The proposed development at Moss Edge Farm (number 2023/91342) is contrary to paragraph 80 of the National Planning Policy Framework as there are no relevant circumstances that would justify the development of isolated homes in the countryside. The Peak District National Park have previously commented on the negative impact of increasing urbanisation (mostly housing) and this development is extremely close to the Parks boundary. The development with its accompanying parking spaces, bin storage and gardens would be detrimental to the Park landscape which Local authorities are obliged to have regard to (Section 65 of the Environment Act 1995). The proposal of three additional properties would increase light pollution in an intrinsically dark landscape and be conspicuously out of keeping with local nocturnal light levels.

Transport and highways

Client		
D. HELEINE		
Project		
MOSS EDGE FARM HOLLIN BRIGG HOLMBRIDGE HD9 2SD		
Drawing Title		
PROPOSED SITE LAYOUT		
Scale (at A1)		Date
AS SHOWN		28.02.2023
Drng. no.	166-23-PL102	Rev.
		A

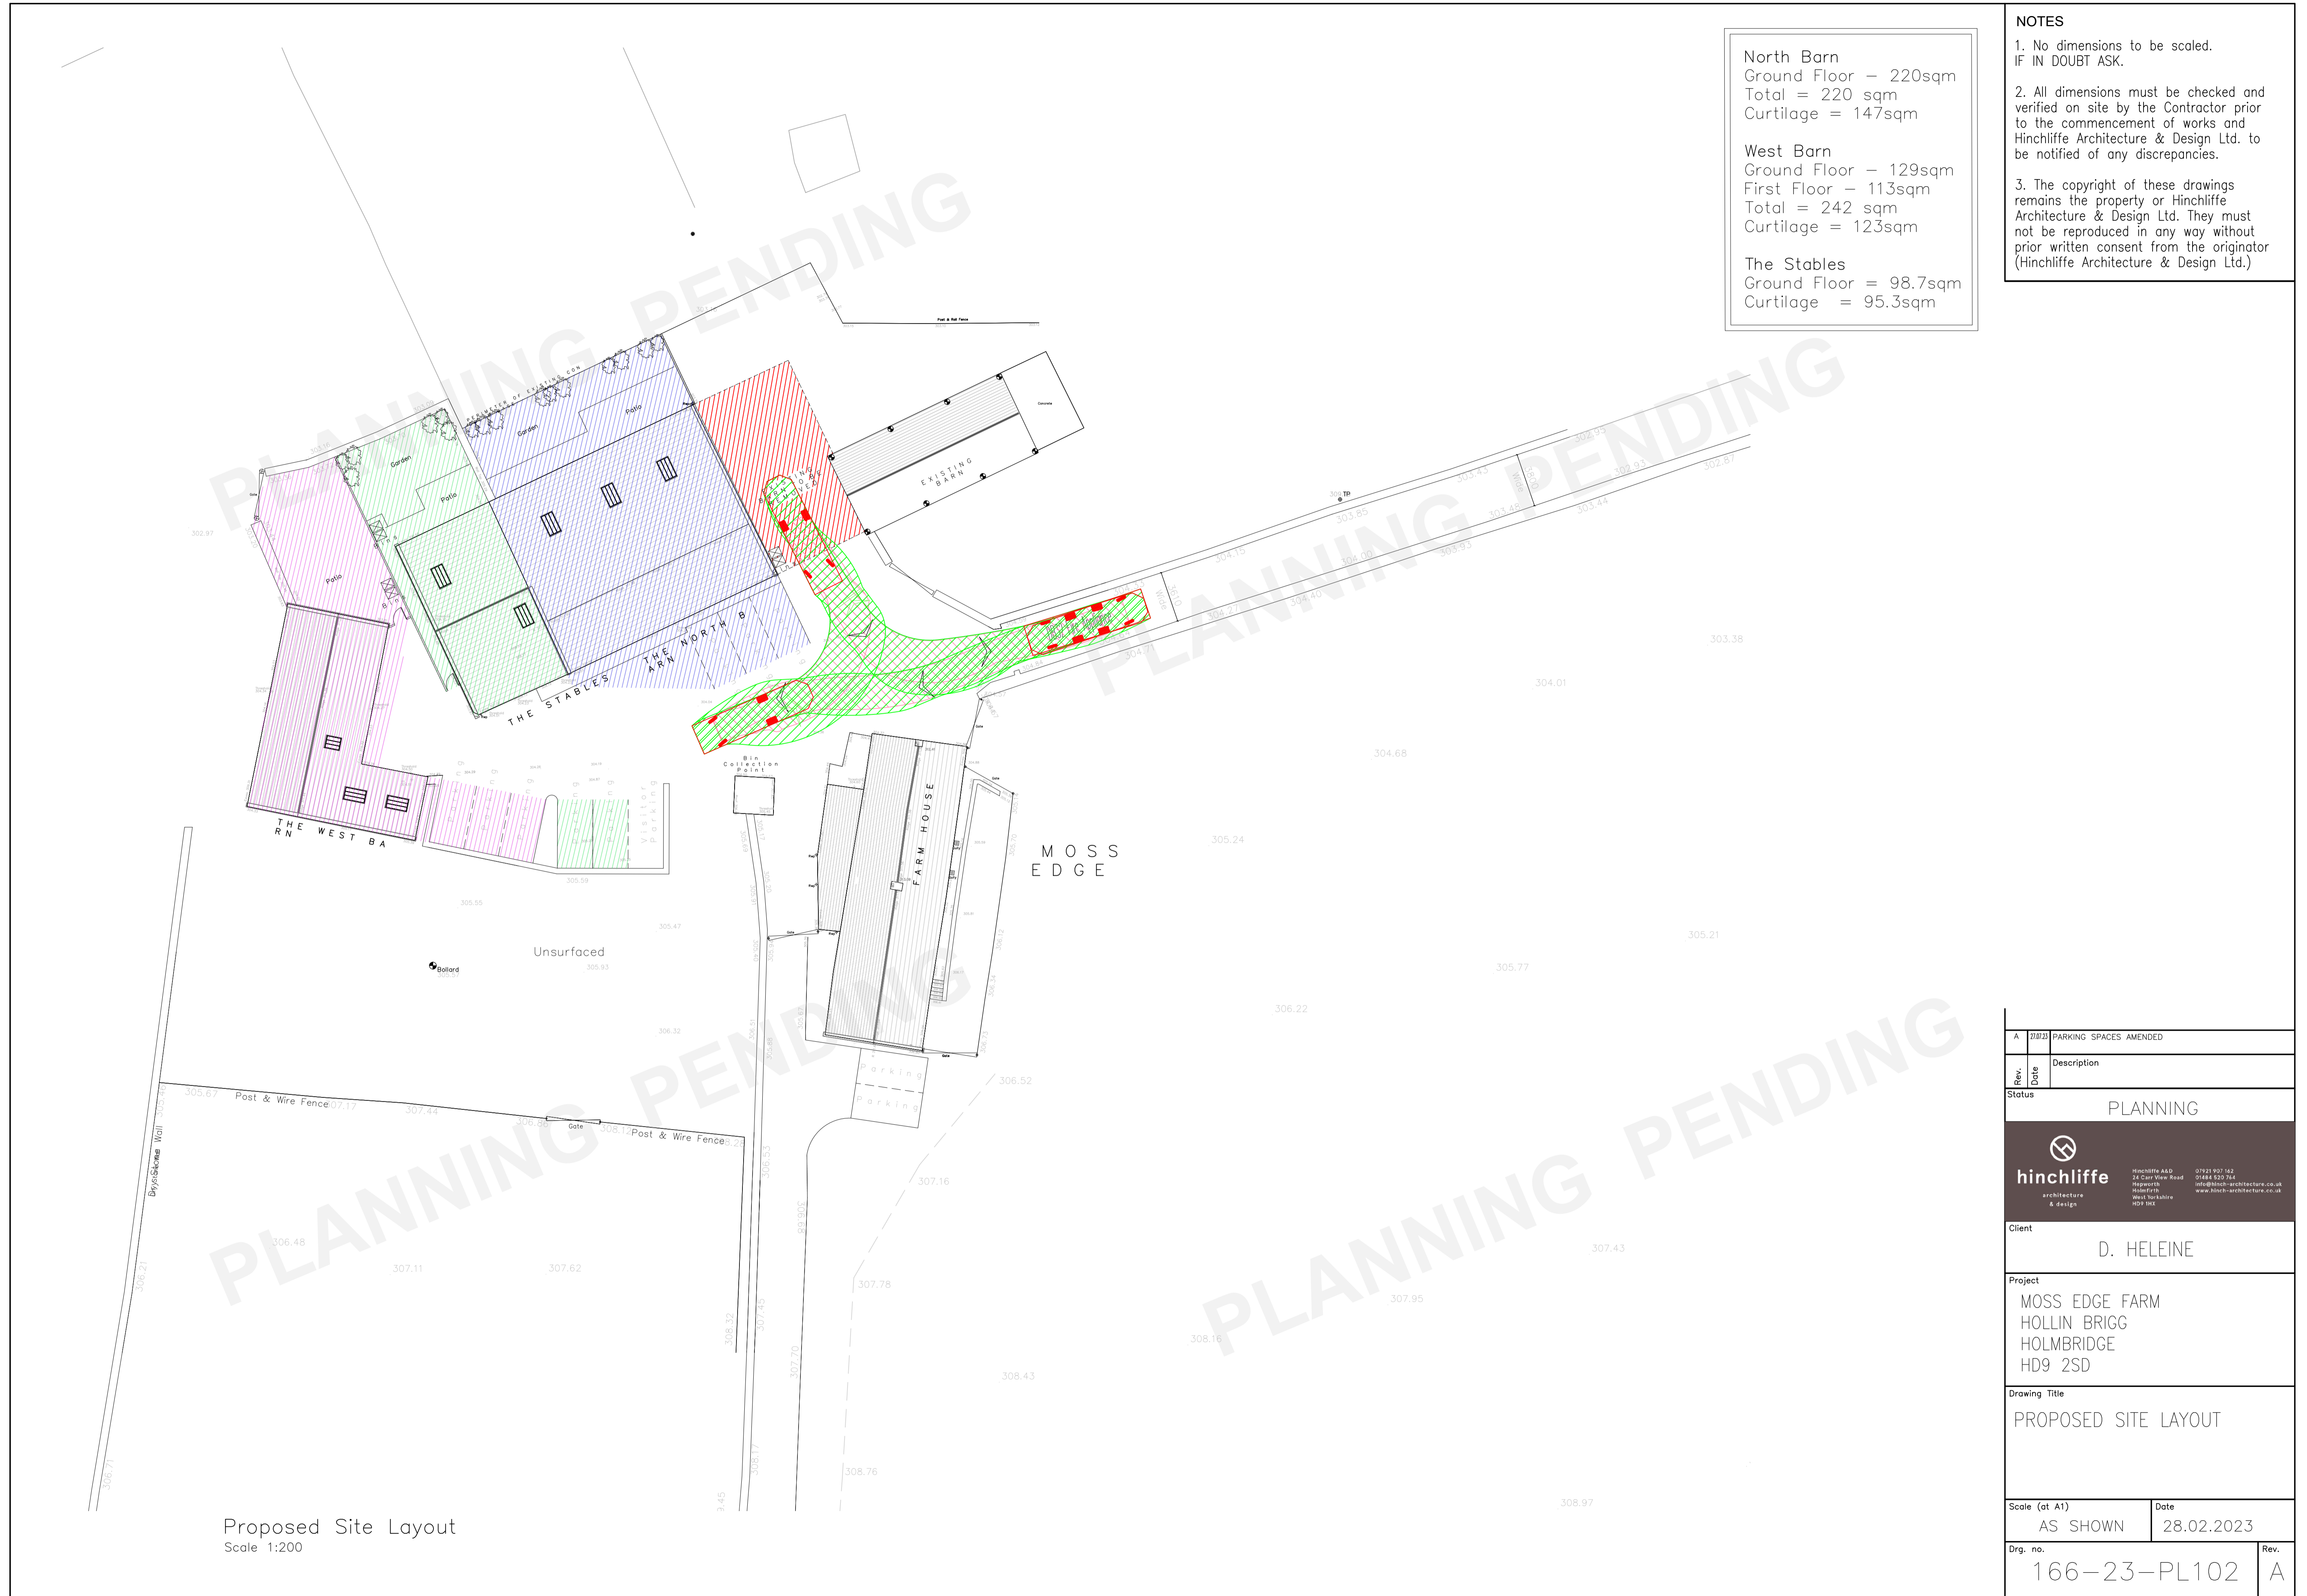
There are no passing places at the bottom of the private lane access where it meets the highway (Acre Lane, Hollin Brigg Lane, Woodhouse Lane). The passing places on the proposed plans would be inadequate to take the increased volume of traffic which would include residents' cars, delivery vehicles etc. Any additional passing places will further damage the woodland and be detrimental to the wildlife in it.
